From: [Jim Sammet](#)
To: [Rachael Stevie \(CD\)](#)
Cc: [CDS User](#)
Subject: RU 22-00002: East Peak Reasonable Use Variance
Date: Friday, April 22, 2022 4:16:00 PM
Attachments: [RU-22-00002 East Peak Site Plan\(f\).pdf](#)

I would like to add the following comments for the record in regard to the subject Reasonable Use Variance application:

Exhibit B - PUD Site Plan

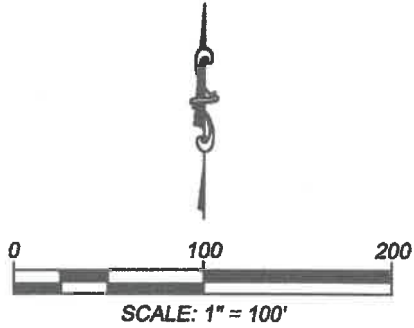
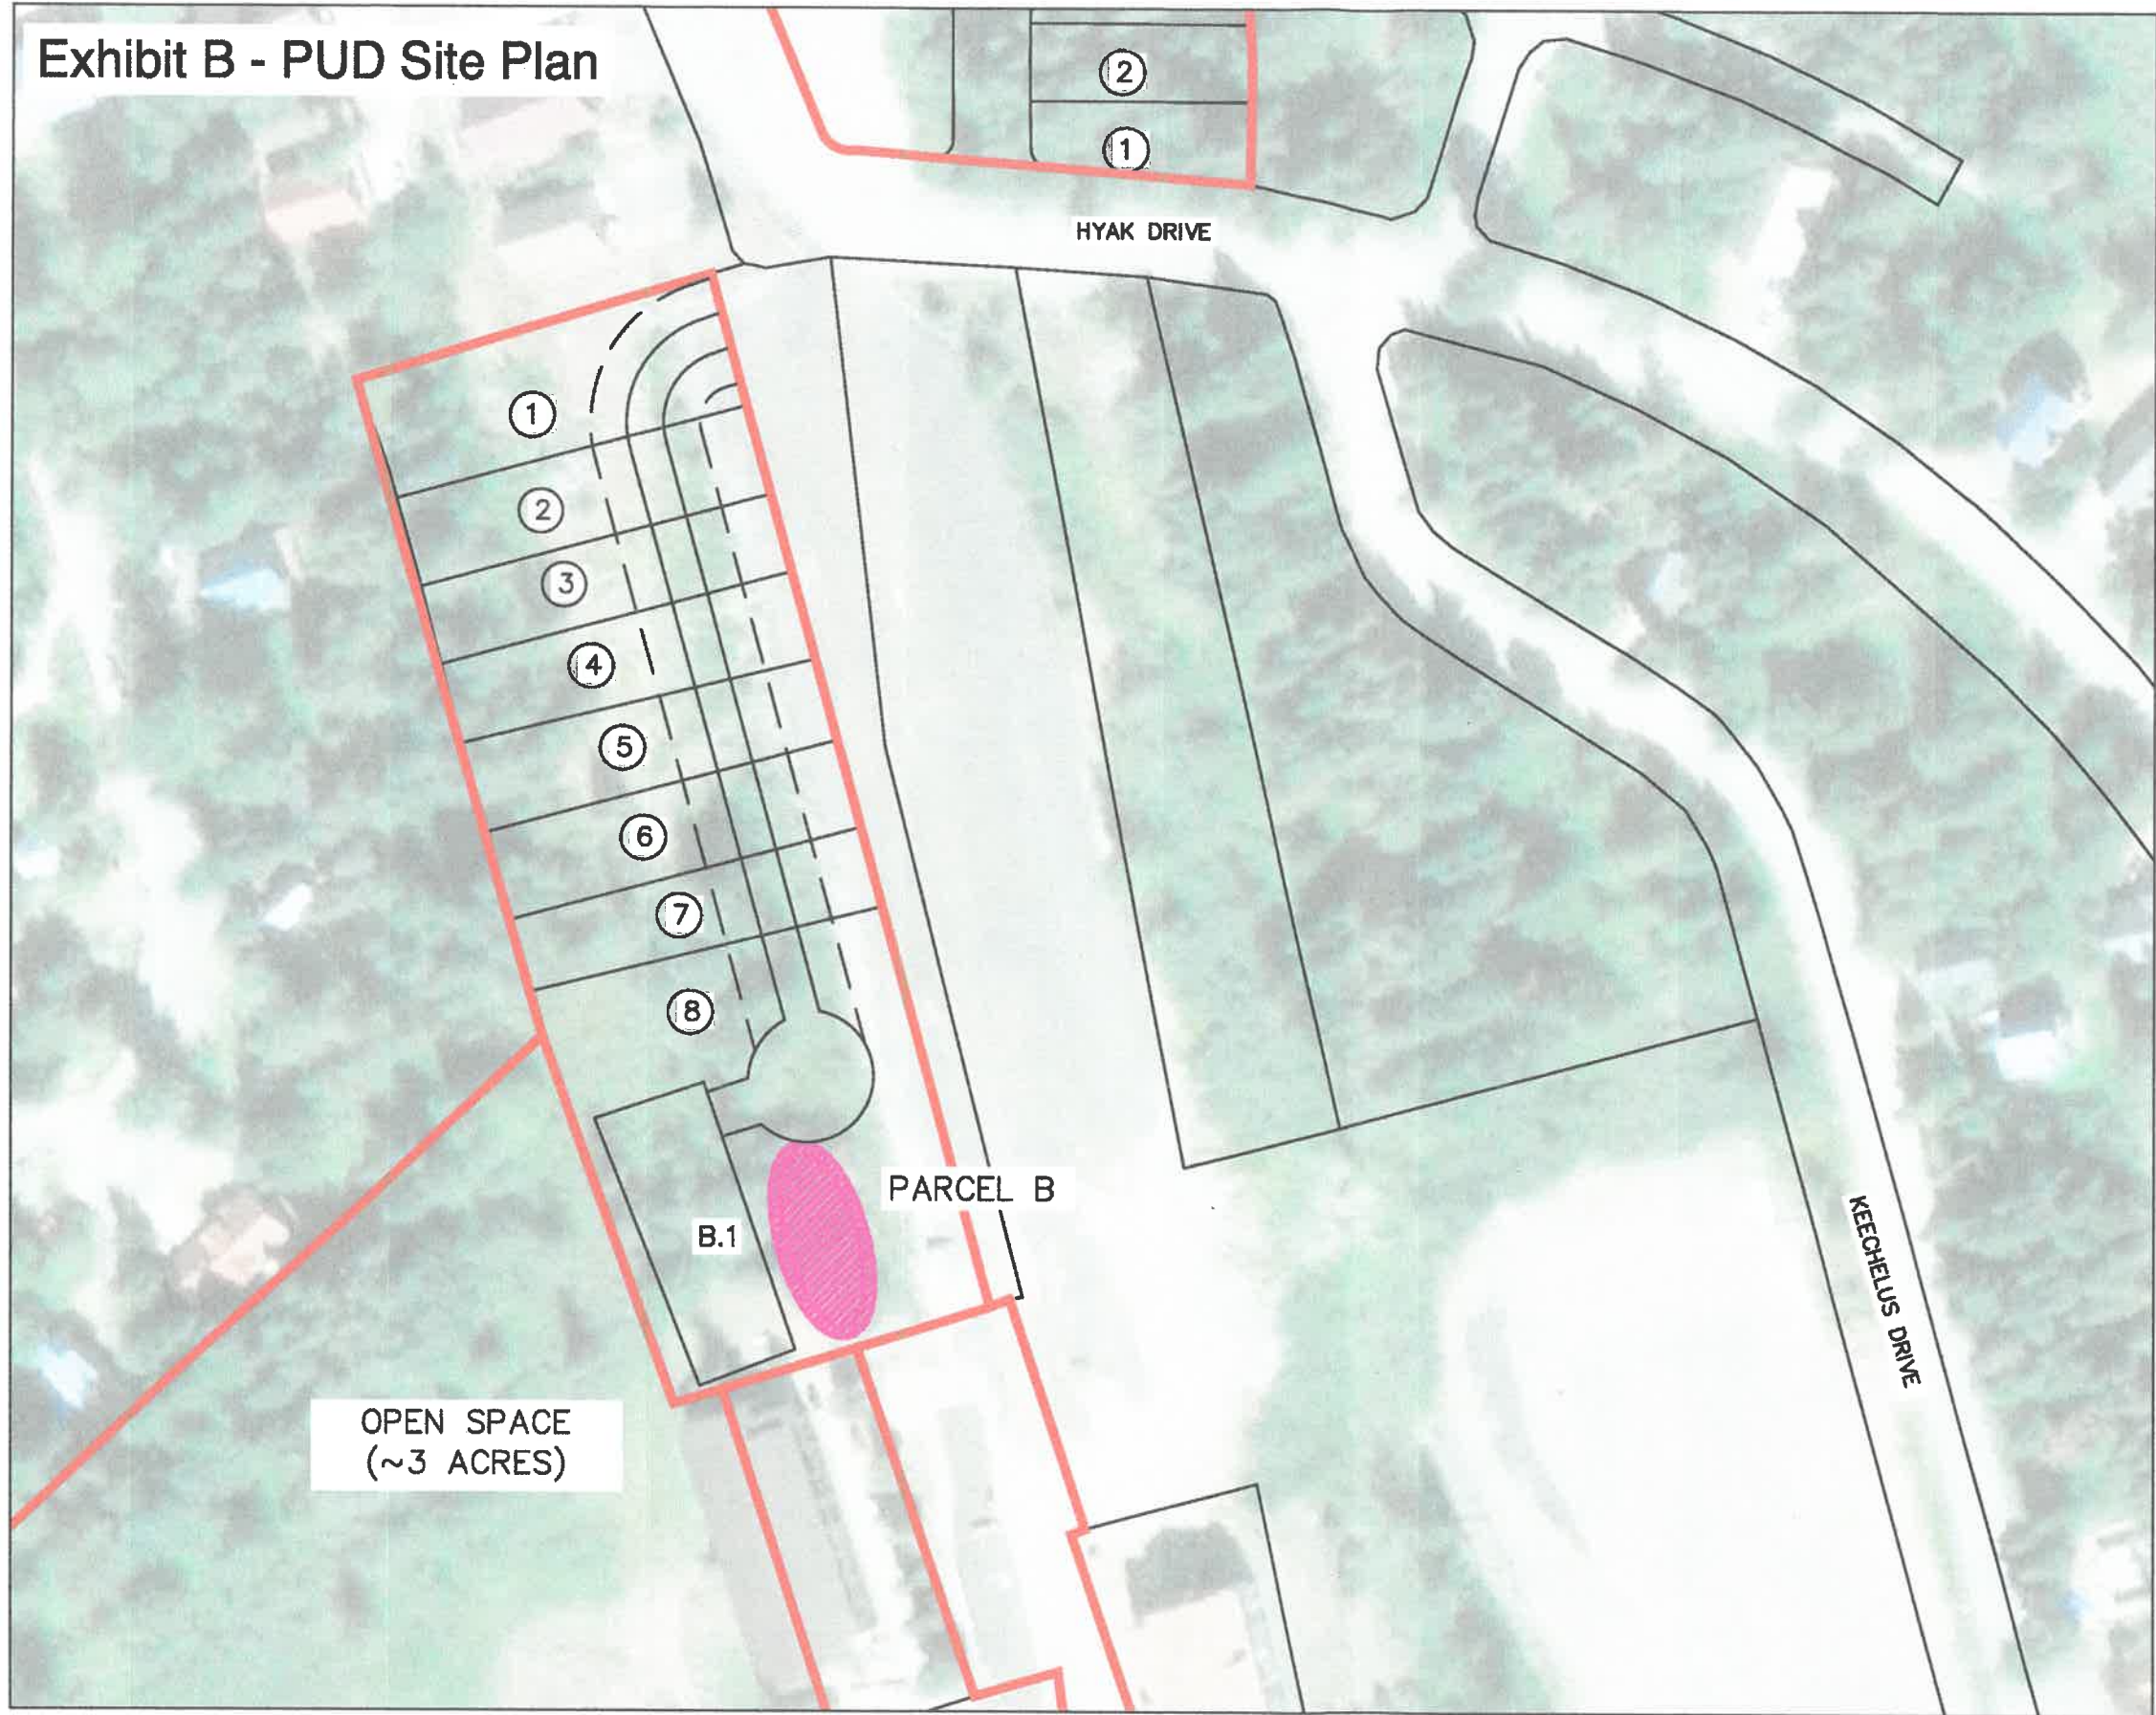
The site plan submitted with the Reasonable Use application differs from the site plan in the approved PUD. The original site plan in the PUD indicates there would be a total of 8 lots with 7 lots assumed from the exhibit to be single family lots and a Multi-Family (Condominium) structure located at the south end of parcel B on lot 8. The site plan submitted with the Reasonable Use application now shows a multi-family structure at the north end of Parcel B and 7 townhome structures located between the Multi Family Structure and the wetland buffer variance sought in the Reasonable Use application. This is a change that affects the existing adjacent single family residences on two sides of Parcel B.

EXHIBIT A - PROPOSED SITE PLAN

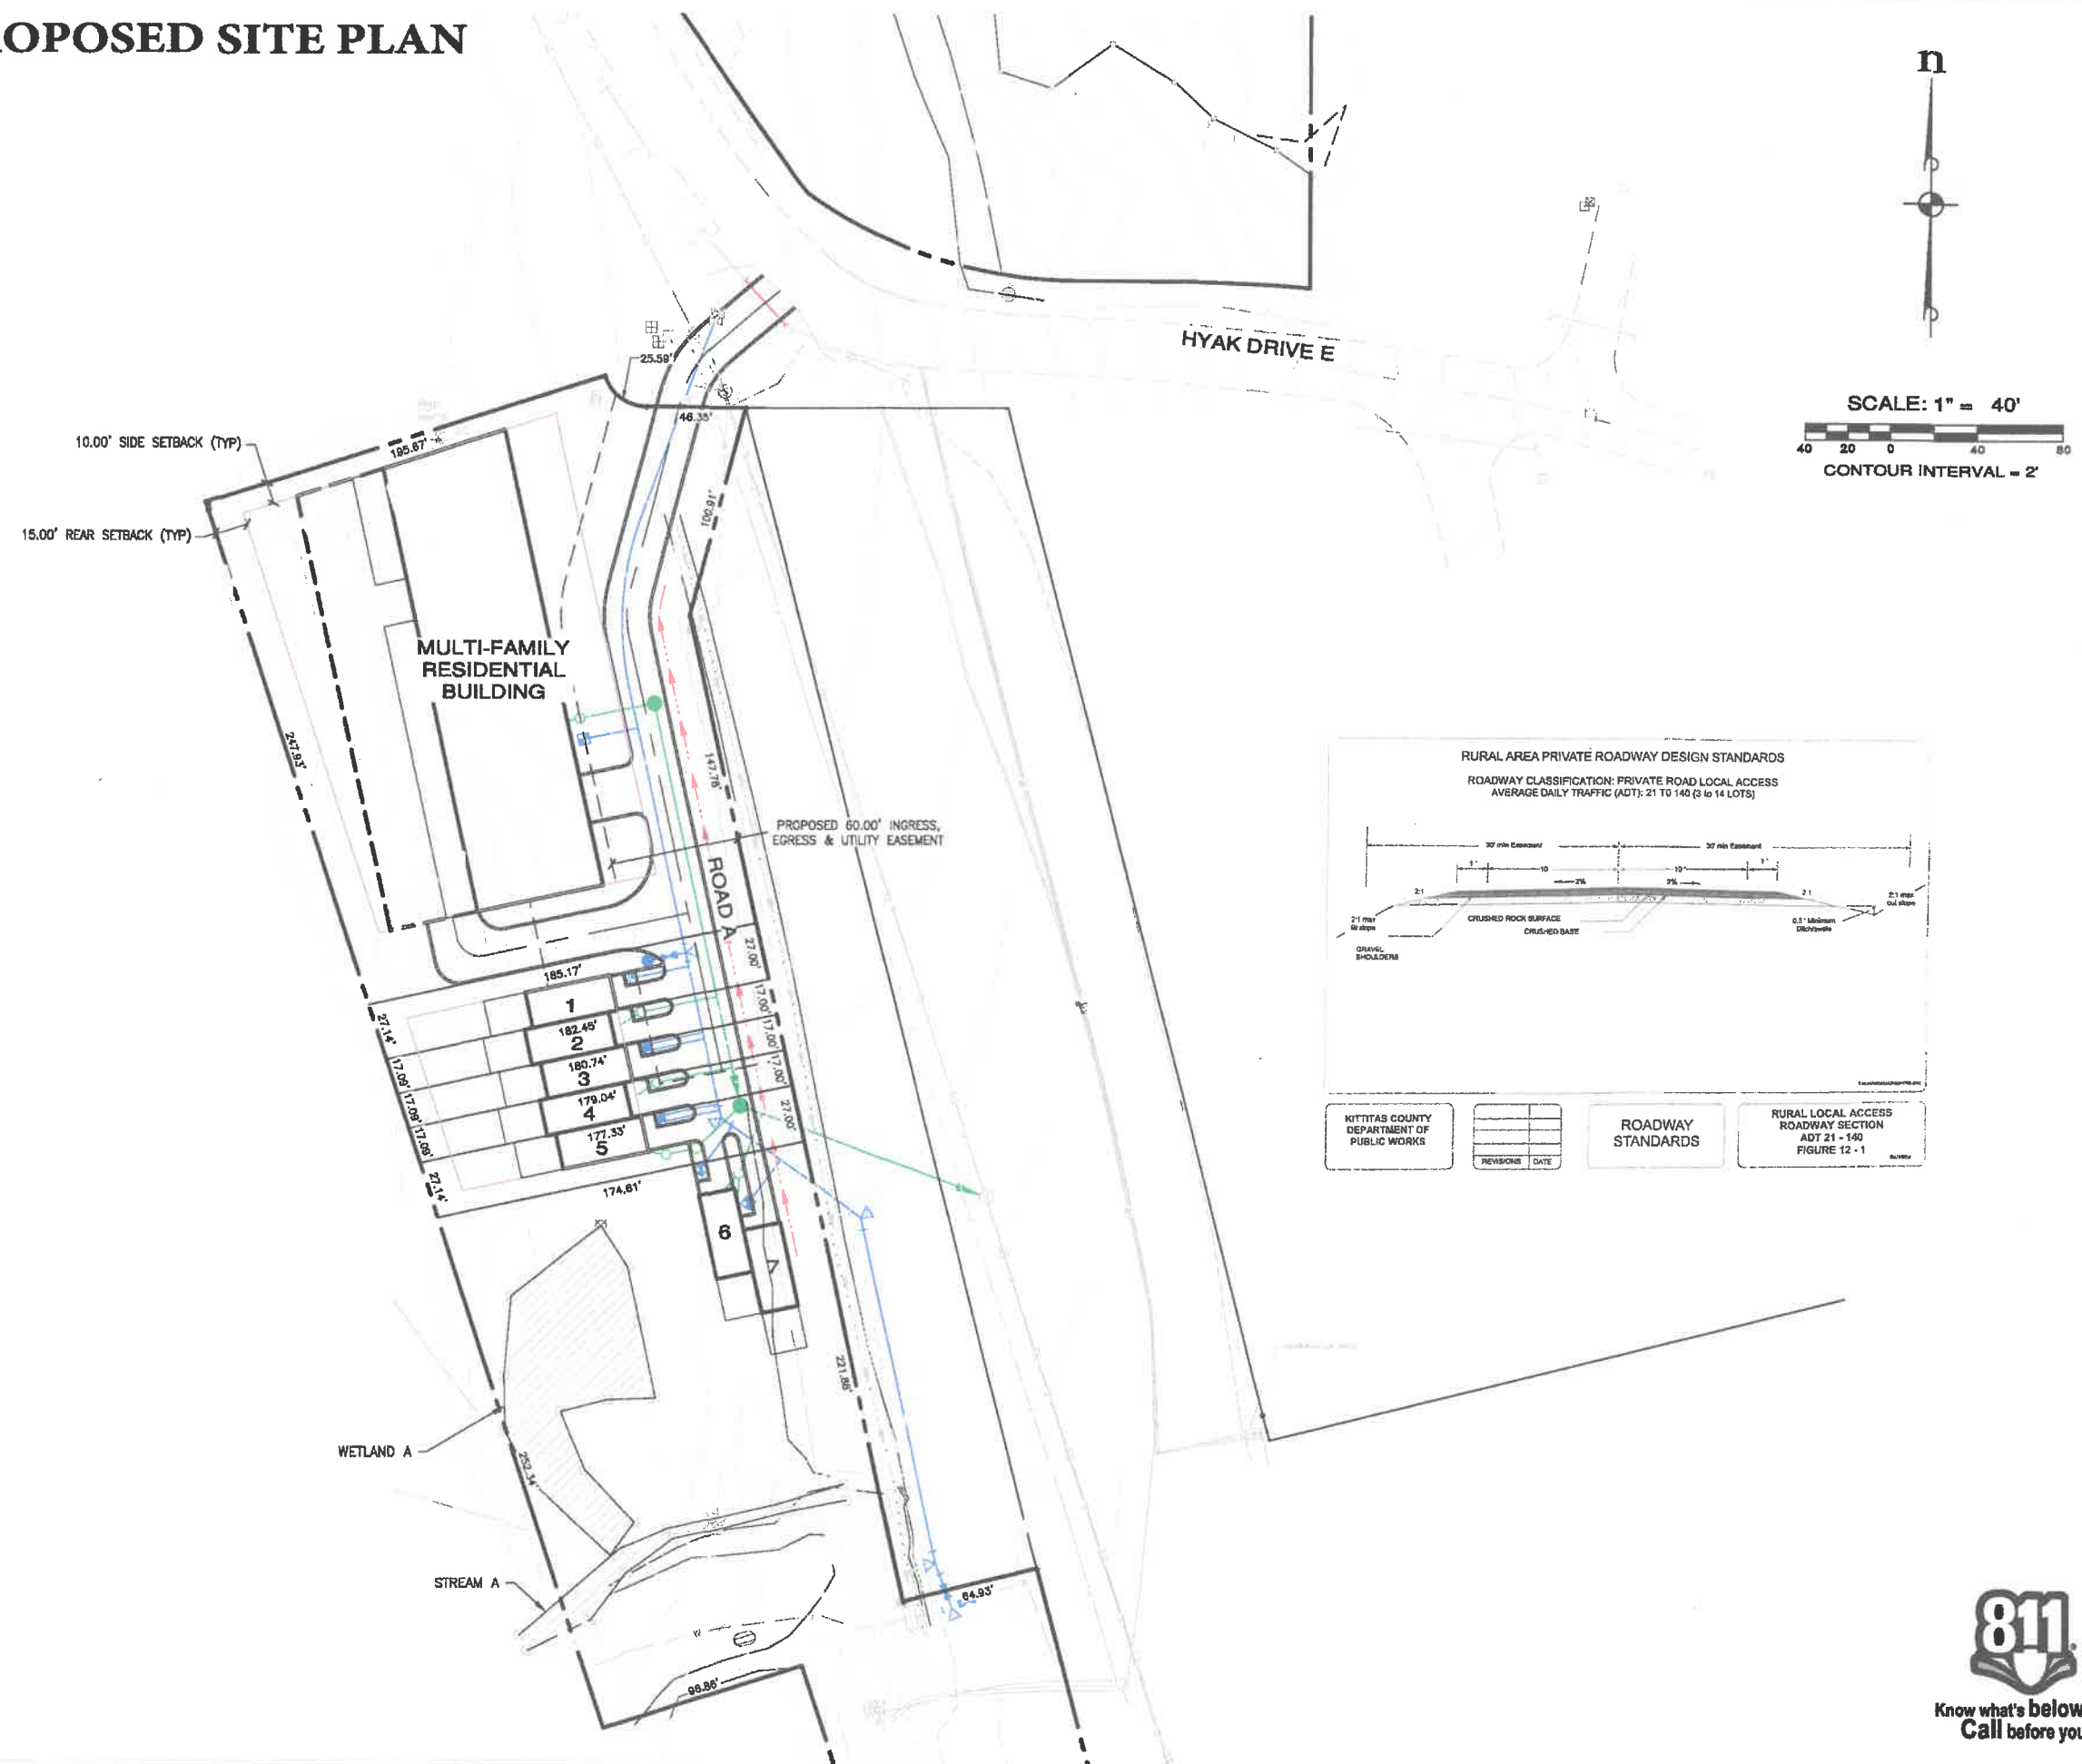
The director should consider zoning, comparable structure size and land use of the surrounding neighborhood in regard to the site plan submitted with the Reasonable Use application. The site plan in the application would locate a large multi-family structure immediately adjacent to single family homes located on the north and west sides of Parcel B. The site plan should consider structure type including density of development in the same manner as Parcel B was originally proposed in the PUD. The density of development should increase to the south towards the Summit East Ski Area Base where several high density multi family buildings are proposed in the PUD. Therefore the Director should consider the following revisions to the site plan as submitted in this Reasonable Use application:

1. The Townhome structures should be located at the north end of Parcel.
2. The Multi-Family structure should be located between the townhomes and

the wetland buffer sought under this Reasonable Use application.

This configuration of the site plan would allow density of development to increase to the south towards the Summit East Ski Area base transitioning from Single Family to Attached Townhome then to Multi Family which will be located adjacent to the existing Sundance Condominiums multi-family structure.
